CITY OF PORTLAND

Permit Number: 061222

has permission to build a new 26' x 32' 2 story Bedroom Family Home

AT 86 RUBY LN Lot #5 341 H018001

ROOF FRAMING PLAN
 SCALE: 1/4" = 1'-0"

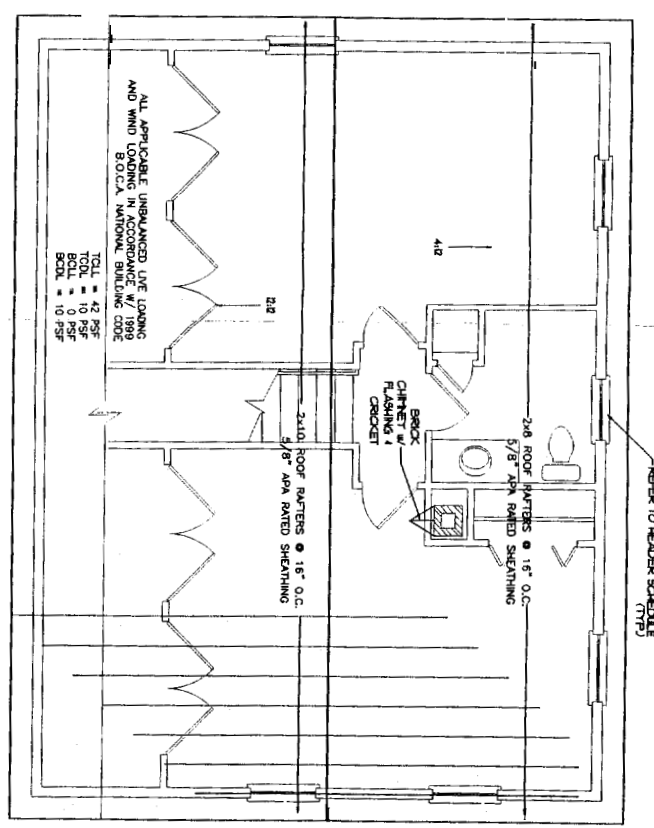
Pitch, Span, Spacing & Dimension (Table R802.5.1(1) - R 802.5.1(8)) Roof Rafter; Framing & Connections (Section R802.3 & R802.3.1)	2x10 & 2x8 2x8 over 12'3"	change ALL 2x10 9/8/06 (2)
Sheathing; Floor, Wall and roof (Table R503.2.1.1(1))	3/4" 7/16" 5/8" Per IRC	OK
Fastener Schedule (Table R602.3(1) & (2))		OK
Private Garage (Section R309) Living Space? (Above or beside) Fire separation (Section R309.2) Opening Protection (Section R309.1)	N/A	OK
Emergency Escape and Rescue Openings (Section R310)	OK noted	OK
Roof Covering (Chapter 9)	Asphalt	OK
Safety Glazing (Section R308)	N/A	
Attic Access (Section R807)	not shown	OK 9/8/06 OK (3)
Chimney Clearances/Fire Blocking (Chap. 10)	As noted	OK Condition
Header Schedule (Section 502.5(1) & (2))	OK	OK
Energy Efficiency (N1101.2.1) R-Factors of Walls, Floors, Ceilings, Building Envelope, U-Factor Fenestration	not shown	FL-19 wall-19 u=35 (3) Attic 38 OK
